Your Ref: OWPC20765
Our Ref: BR/281/18/PL 06-11-2018
Please ask for:
Mr S Davis

Demolition of existing dwelling & erection of a three story building to provide 9 No. flats,
6 No. 1 bed & 3 No. 2 bed units with associated amenity areas, access & car parking.

99 Victoria Drive Bogor Regis

PROPOSED FIRST FLOOR PLAN

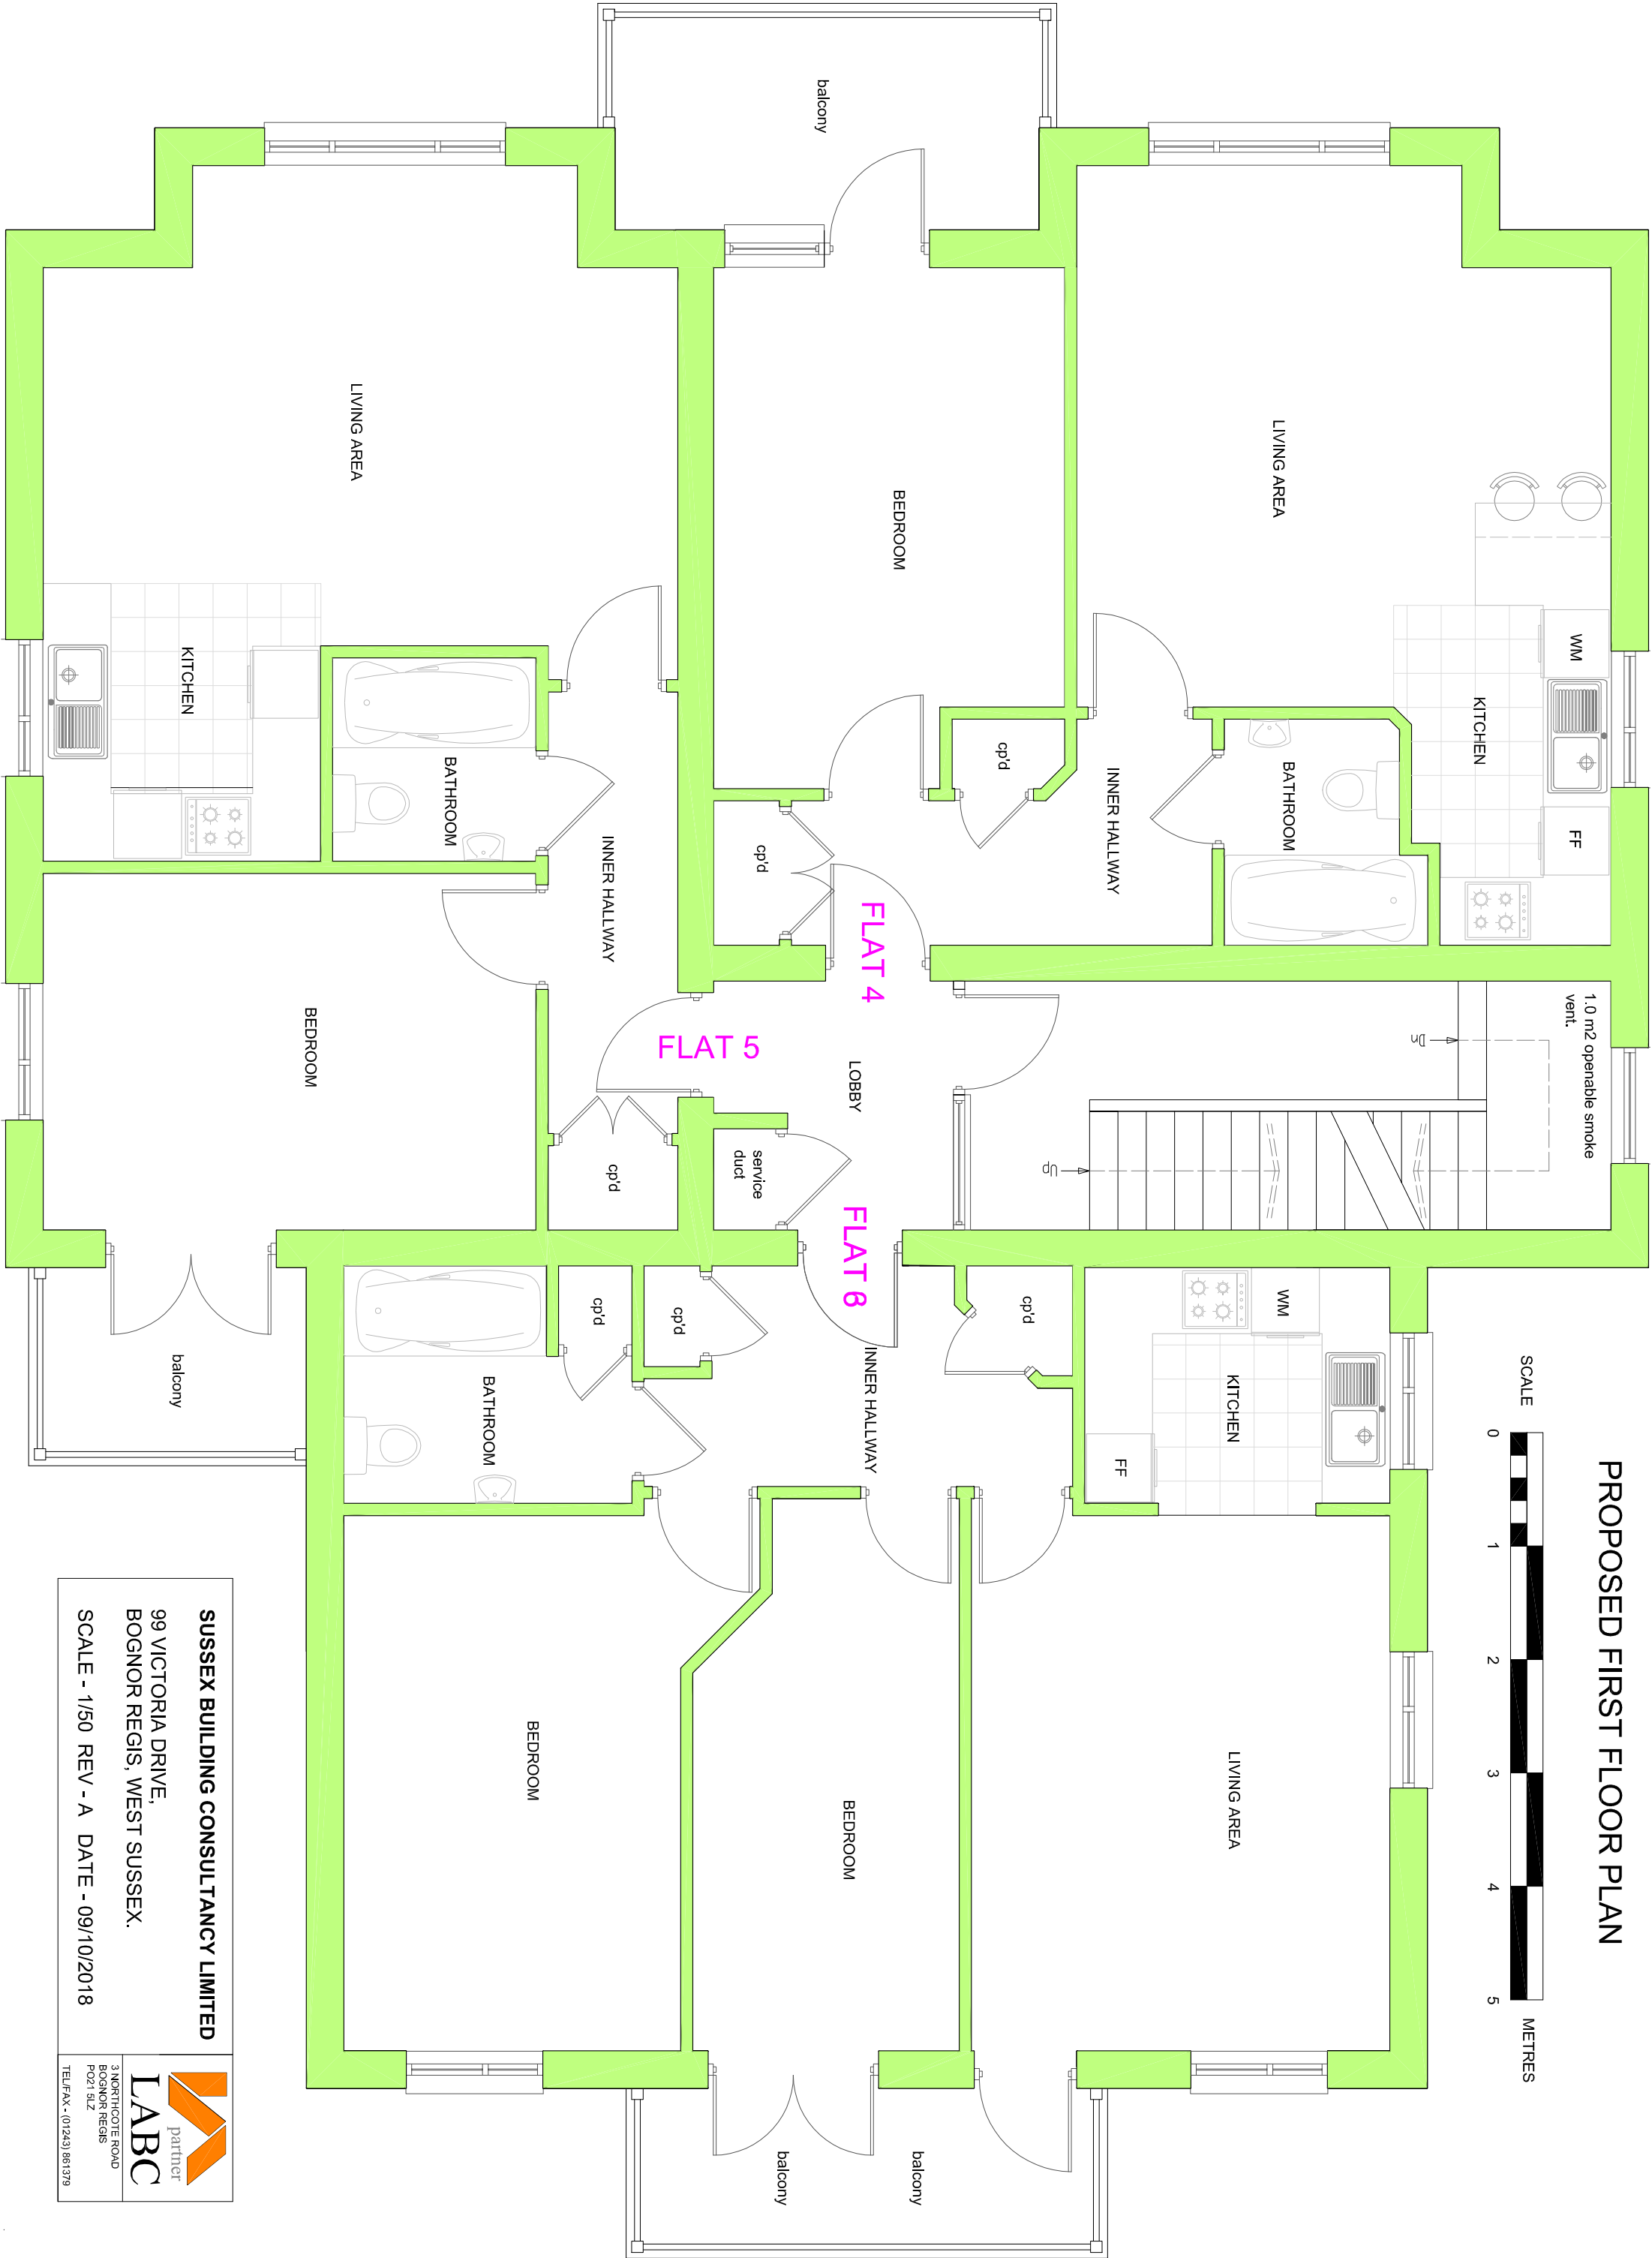
Our private garden space would be totally overlooked as would our house from both the first and second floors of the new building. The balconies would have a view down onto our garden giving us no privacy at all, which in itself should be enough to stop the application. Extending the building so far rearwards would block a huge amount of the sky and allow the new residents to look into virtually every room of our house.

There is no mention on the plans of having the side windows frosted which gives even more of a privacy concern.

PROPOSED GROUND FLOOR PLAN

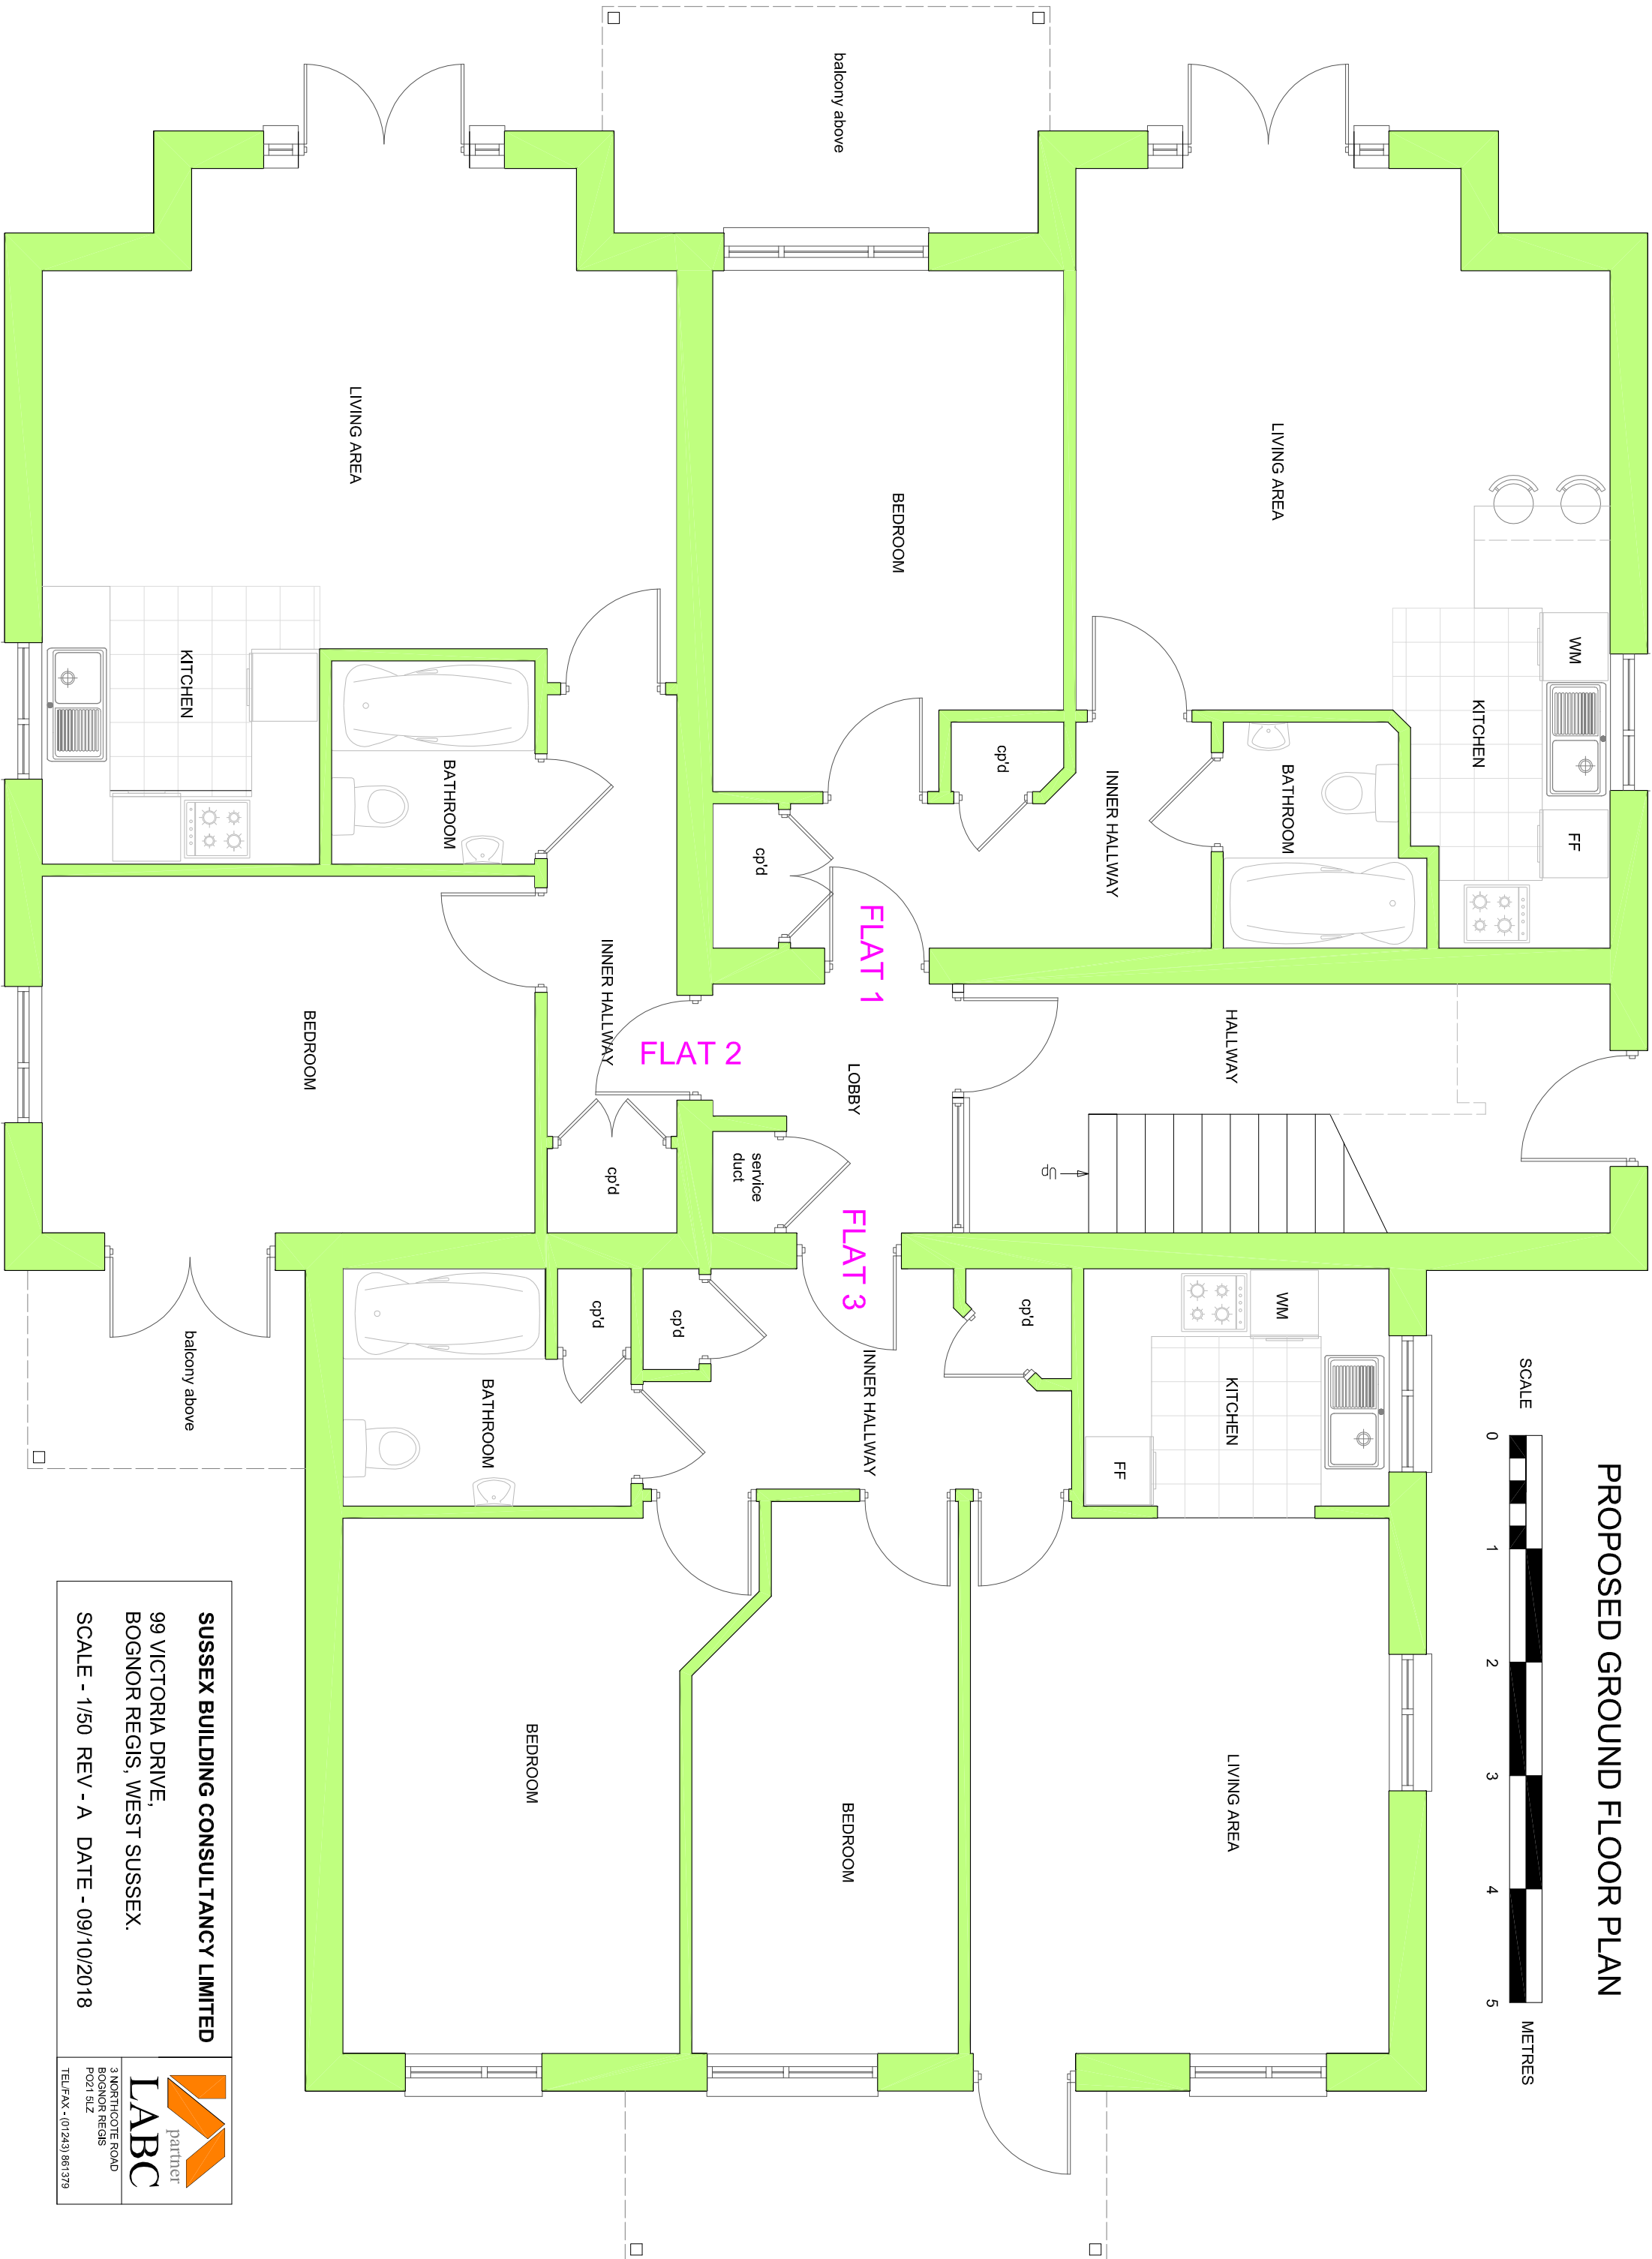
There would be a large number of additional cars to park on the already busy Victoria Drive, providing only 9 spaces for 3 2-bed and 6 1-bed flats is naive to say the least, as you can see from all developments further up the road. Positioning the car park in what was a lovely garden robs the whole area of important wildlife and biodiversity space. It would also put loud polluting cars amongst several neighbouring gardens.
